## RESPONSE TO REVIEW COMMENTS

### **WALDEN PRESERVE 2 – AMENDED PRELIMINARY PLAN APPLICATION SP-18-005**

March 11, 2019

RURAL RESIDENTIAL - PAVED
TYPICAL SECTION (A)
SCALE: 1"=50', 1"=25'

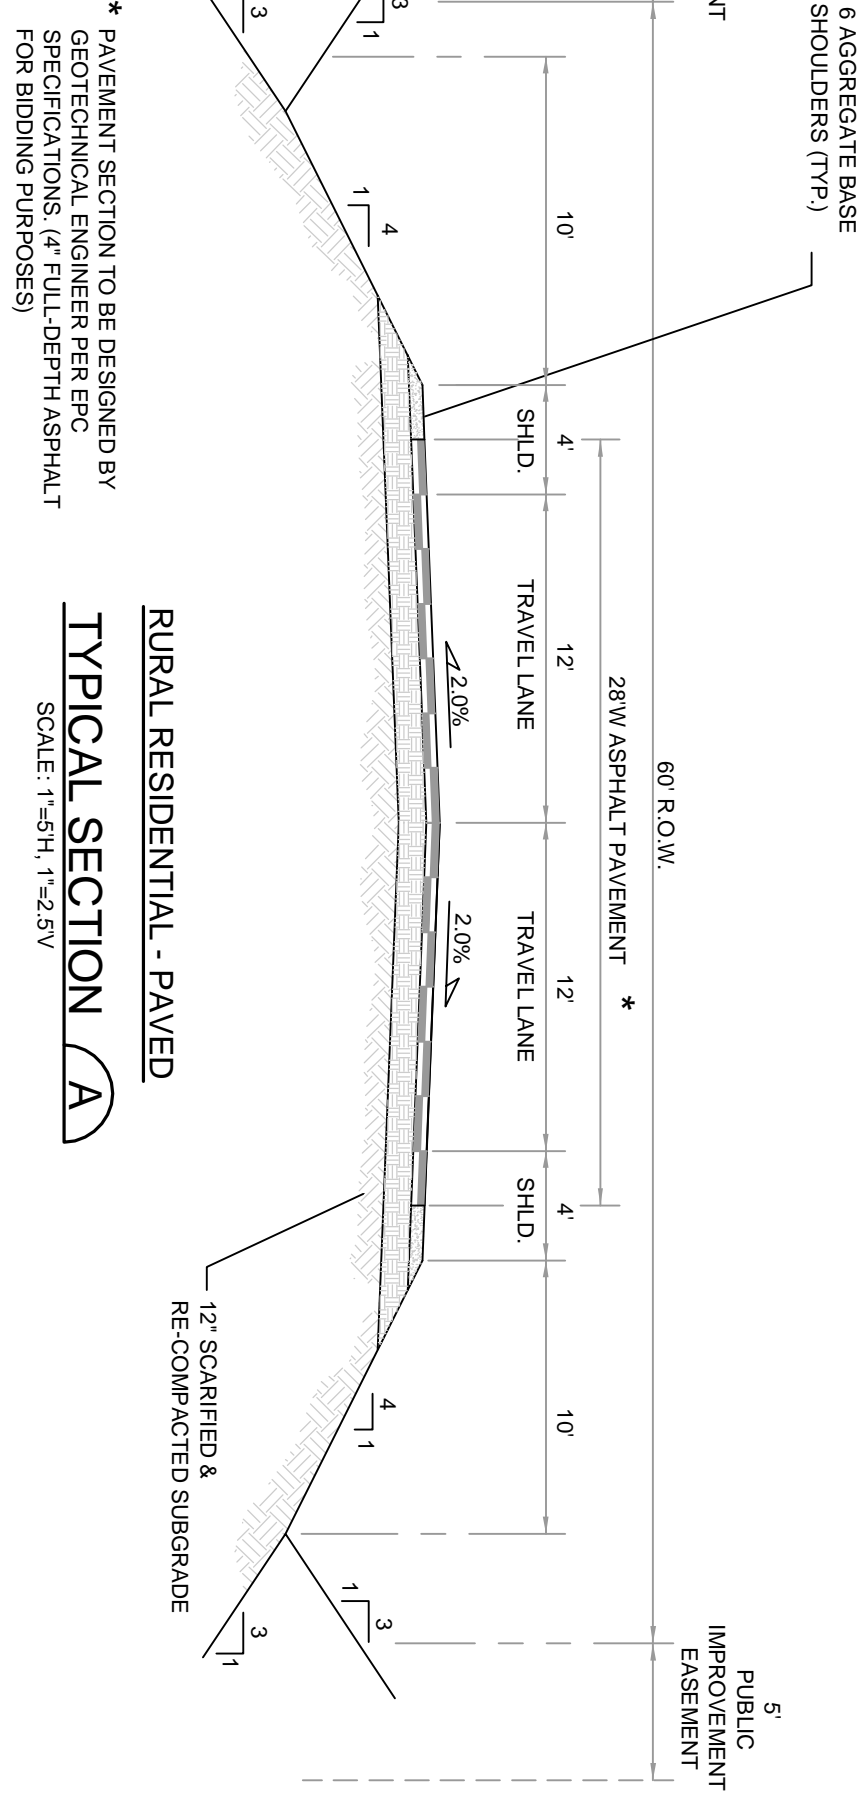
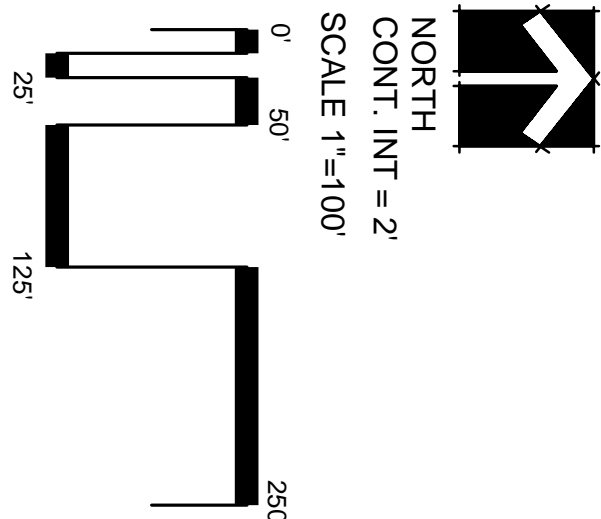
Sheet 4 – *Revise roadway cross section per ECM requirements* – The roadway cross section has been up-dated to reflect aggregate base course daylighting horizontally to the side slope.

SHEET TITLE
COVER SHEET

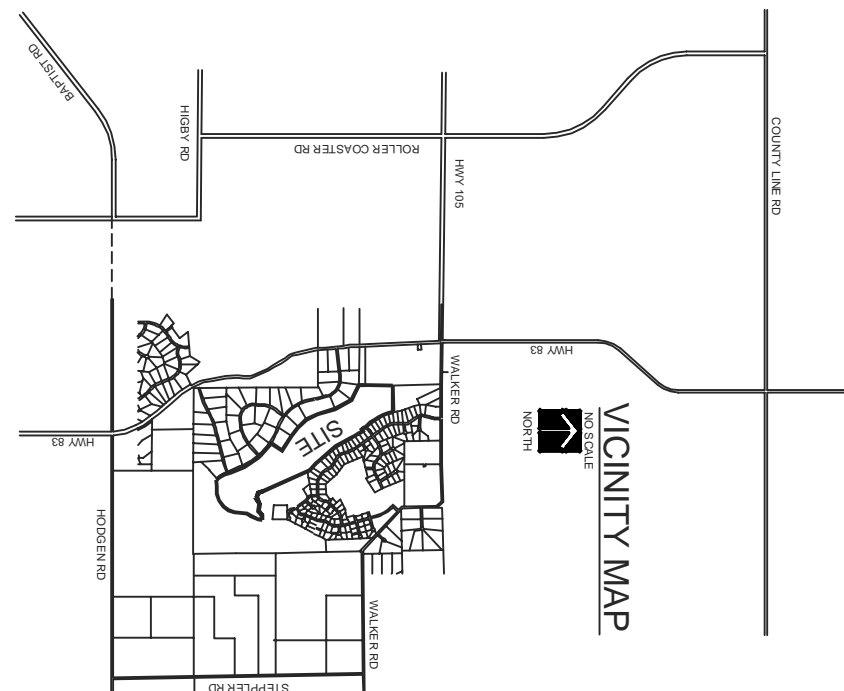
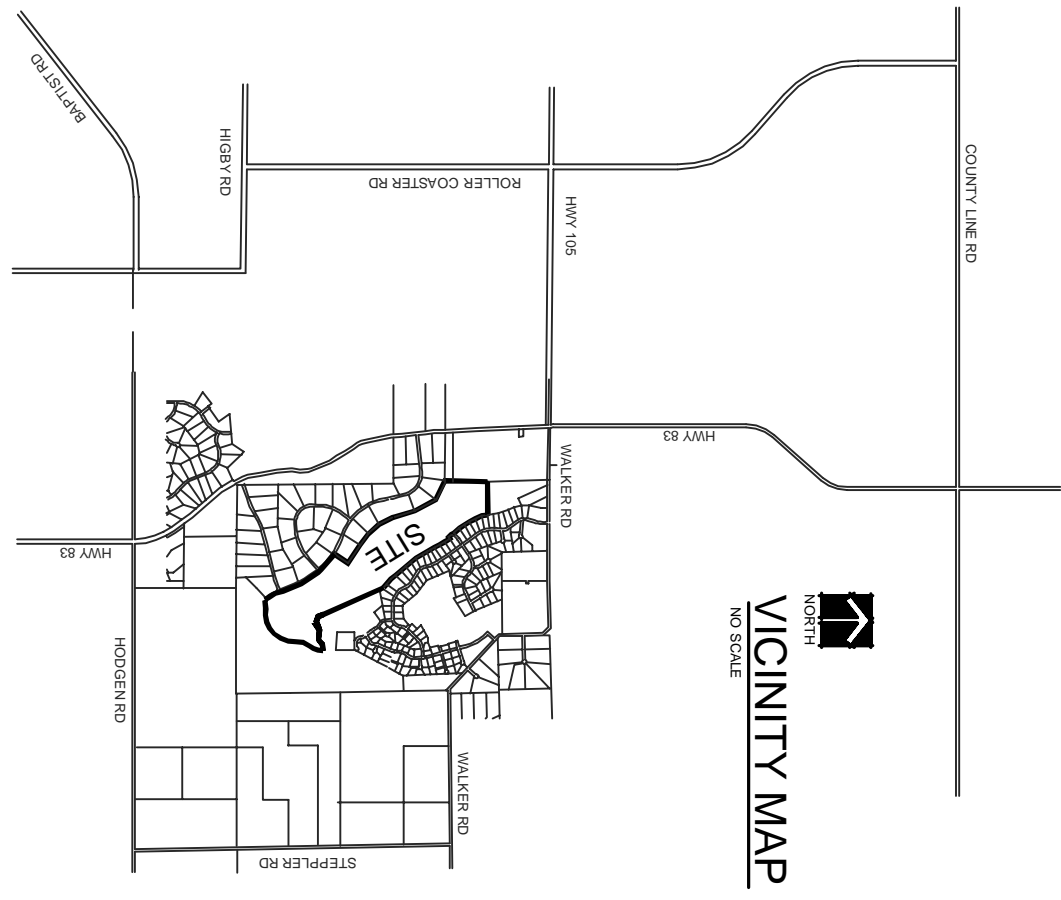
Sheet 1. – *Unchanged area delineation* – As the scope of the proposed Preliminary Plan amendments has increased, all areas within the application (parcel no. 6123001023 as illustrated on Sheet 1) have been modified to one extent or another.

Sheet 1 – *Remove notes that are no longer applicable* – All notes that are no longer applicable to this application have been removed.

Sheet 1 – *Standard PCD Preliminary Plan Notes – This is for the preliminary plan and not final plat* – So noted.

Sheet 1 – *Spell out “Preliminary”* – The abbreviation “Prel” has been revised to “Preliminary”.

Sheet 1 – *Replace all References from “Development Services Department” to “Planning and Community Development Department”* - All references to DSD have been replaced by P&CDD.

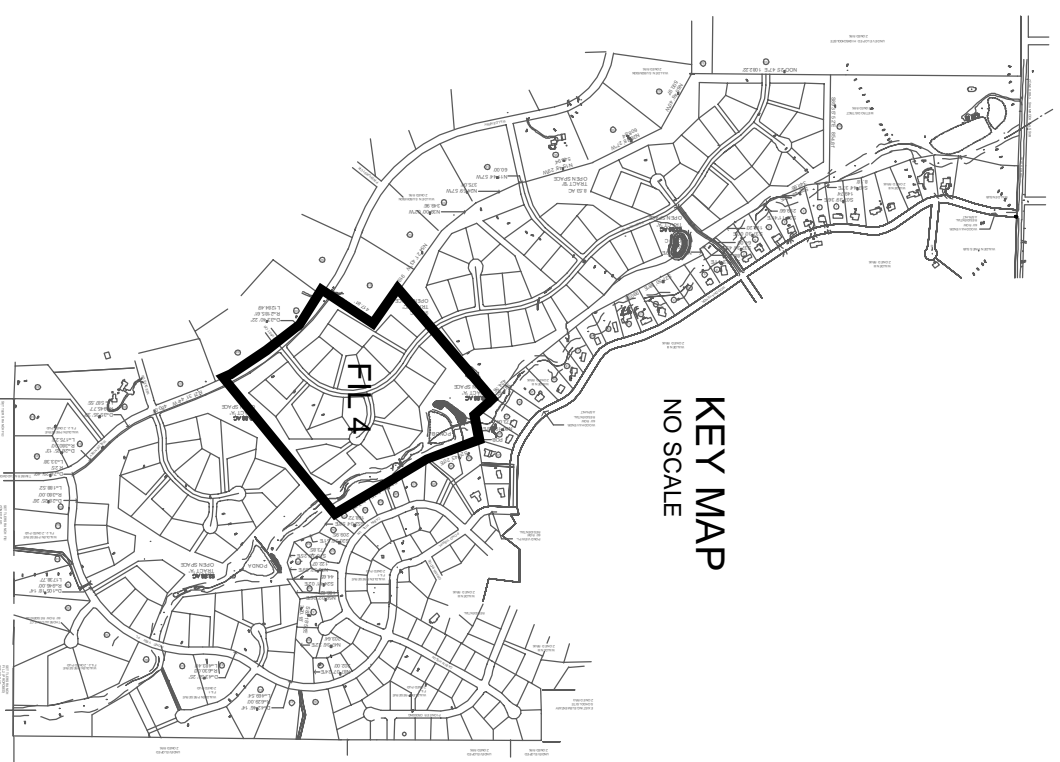
Sheet 2 – *Driveway access to more than 3 lots* – All lots containing a combined access (driveway) easement have been limited to accessing a maximum of 3 lots with the included lot numbers identified on the drawings.

Sheet 2, 3 and 4 – *issues related to combined access (driveway) easements* – The intent is to provide combined driveway access for up to three lots. Access easements must touch or adjoin any lot being provided common driveway access. Where an easement provides access to 2 lots, the easement is centered on the lot's common property line flag stem and is 30' wide. Where an easement provides access to 3 lots, the access easement is configured such that 30' of the easement width is contained within the flag stem adjoining the non-flag lot being provided access and an additional 15' of width is provided within the adjoining flag stem for a total of 45' of easement width. This technique allows for the actual driveway being centered upon the common flag stem property line while providing legal access to all 3 lots involved. Specific easement locations, widths and lots being accessed by the combined access easement are identified on the Preliminary Plan. Provisions related to common driveway use rights and maintenance requirement and responsibilities are contained within the subdivision's Restrictive Covenants and are consistent with Filings No. 1 through 3. The Walden Preserve 2 Restrictive Covenants are included within this re-submittal package.
